From: [Mau, Russell E \(DOH\)](#)
To: [Kelly Bacon \(CD\)](#)
Cc: [Holly Erdman](#); [Smits, Brenda M \(DOH\)](#); [Hayden, Kathryn E \(DOH\)](#)
Subject: RE: Notice of Application - LP-21-00003 Stanavich
Date: Friday, October 22, 2021 11:09:10 AM

The Department of Health (DOH) Office of Drinking Water (ODW) has reviewed the application and has the following comments:

Subject: Notice of Application - LP-21-00003 Stanavich

STANAVICH AG PLAT
PART OF SECTION 35, T. 19 N., R. 18 E., W.M.
KITITAS COUNTY, WASHINGTON
- PRELIMINARY PLAT -

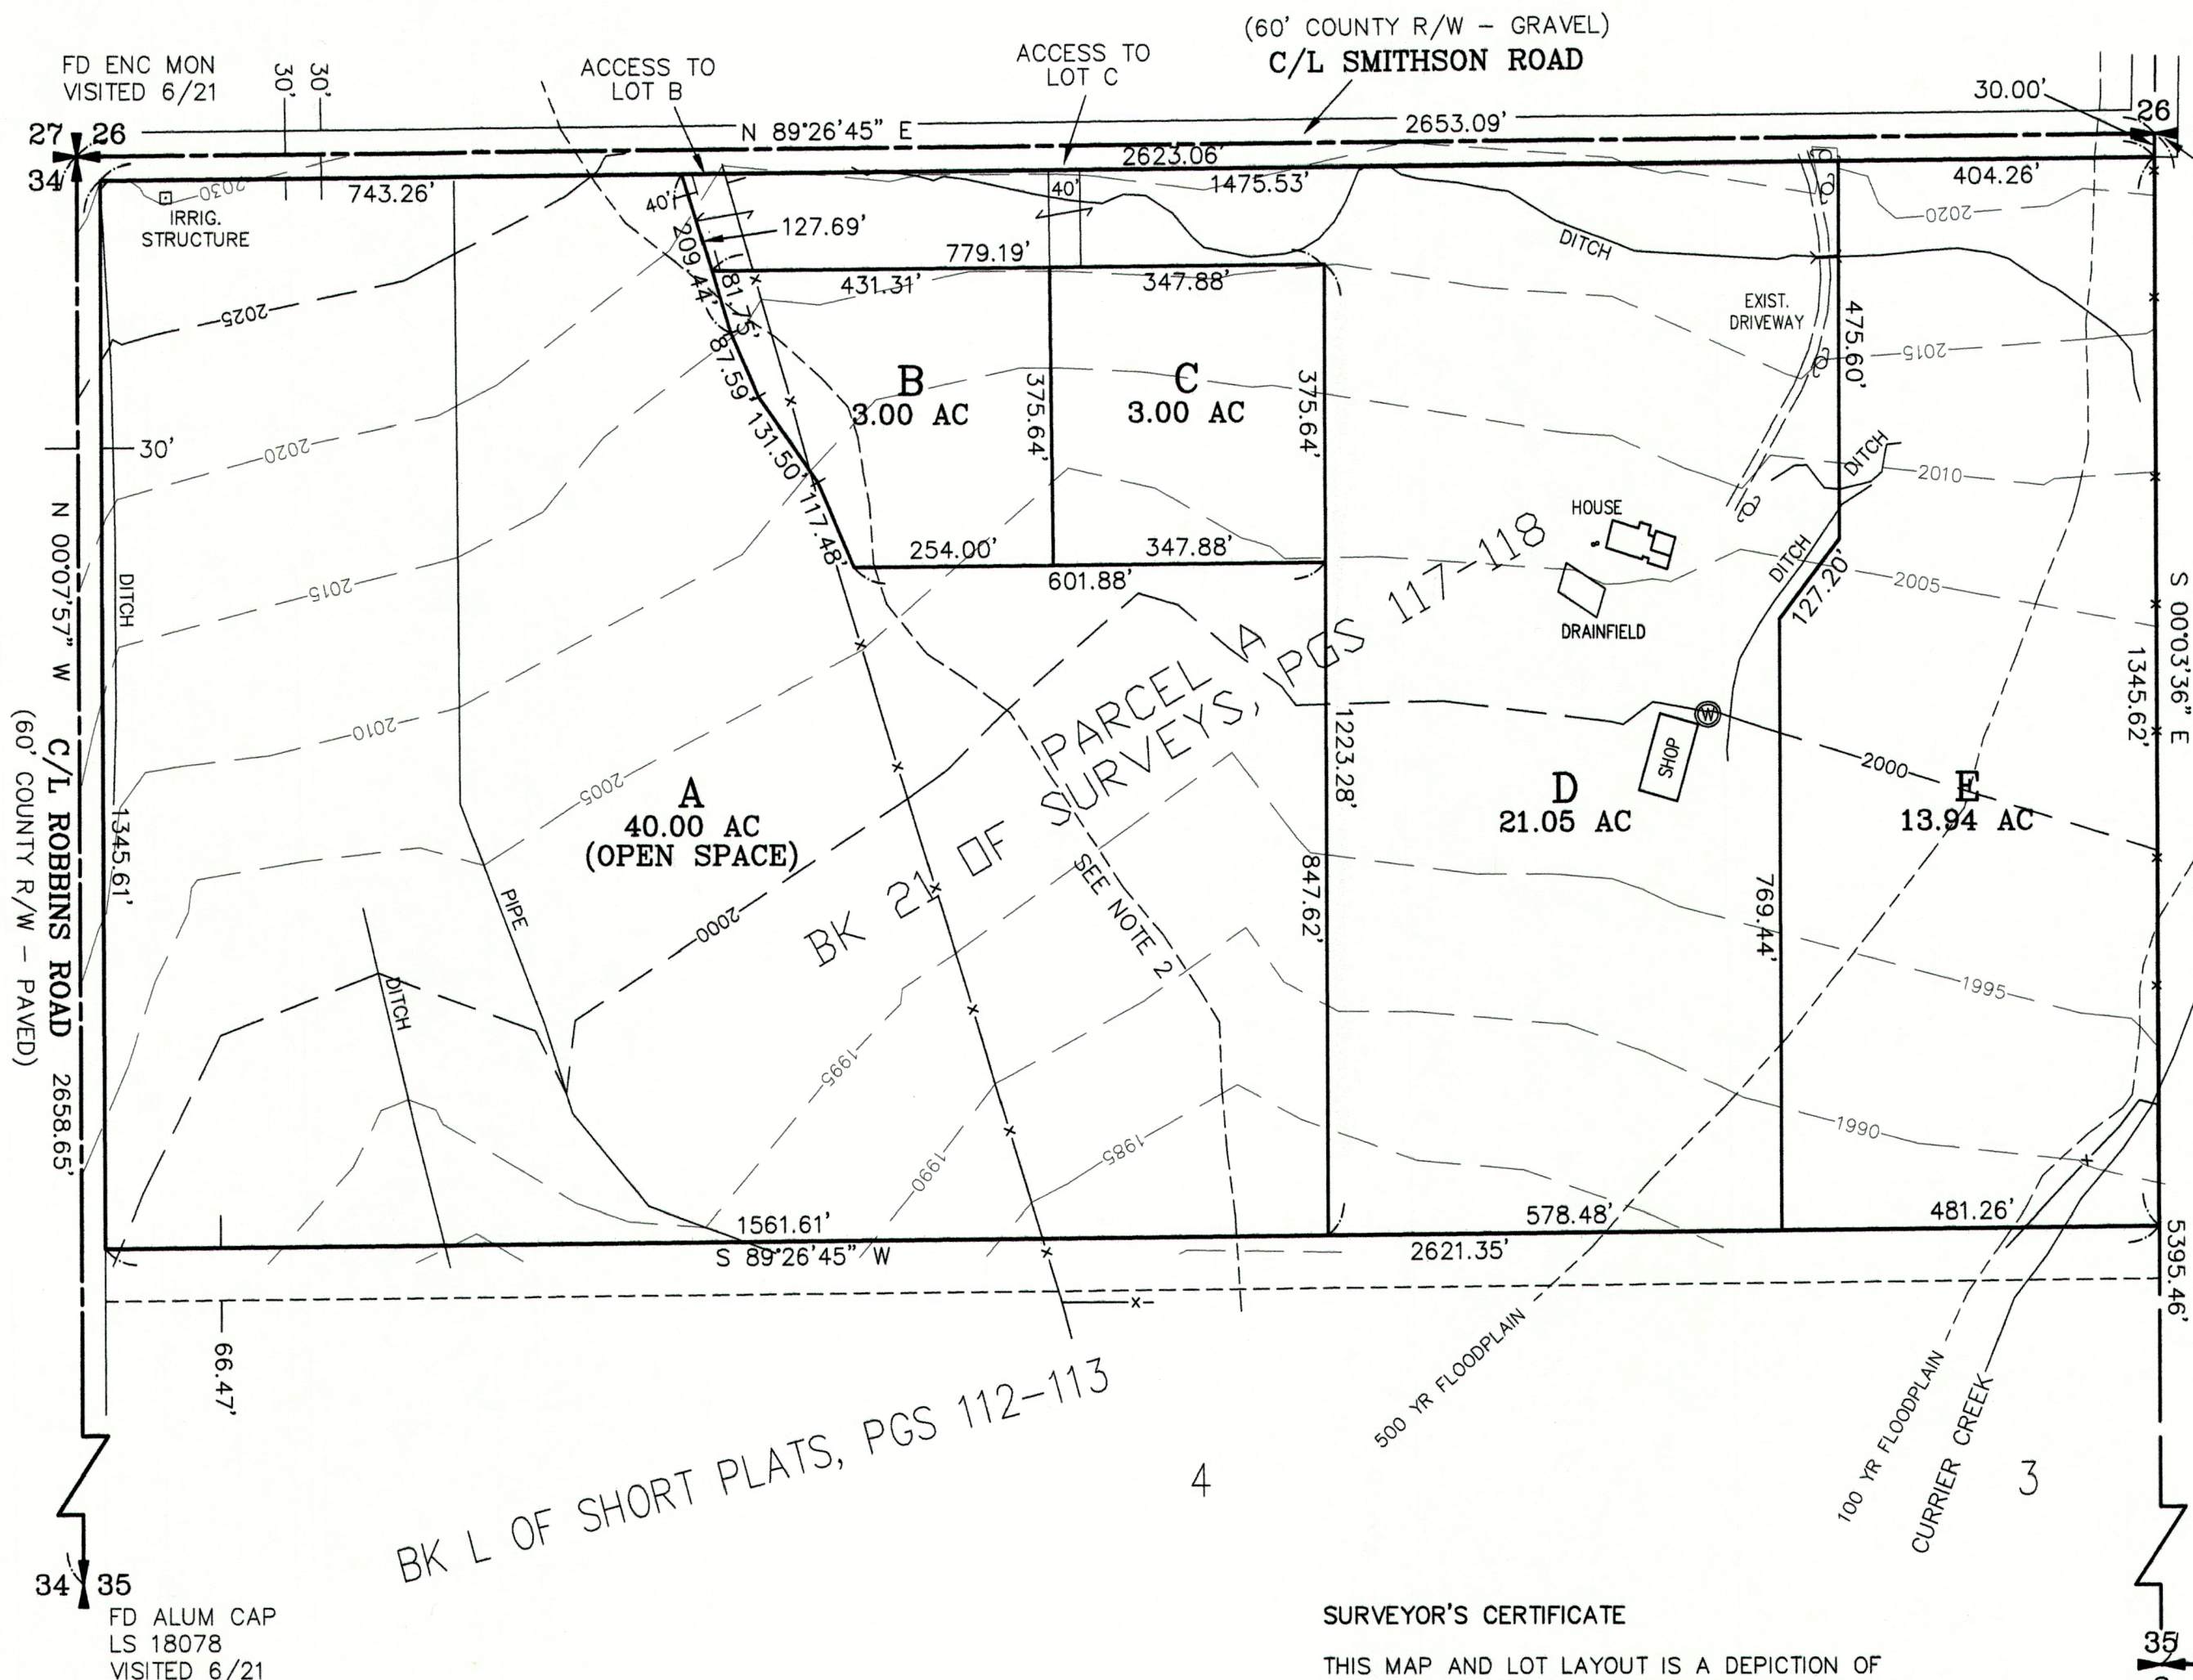
- The applicant indicates the water utility is “existing”. It appears that this is an existing on-site private well. Please confirm.
- If the applicant intends to connect all homes to a single well or multiple wells, then this would constitute a Group B public water system requiring review and approval from Kittitas County Health.
- If the applicant intends to install multiple individual or private wells, then this water usage is defined as a “project” by the Department of Ecology and all water use needs to be evaluated as a single quantity. In other words, even if several private wells for the individual homes, the total water usage cannot exceed either a single exempt well quantity of water or cannot exceed the total of any water rights.
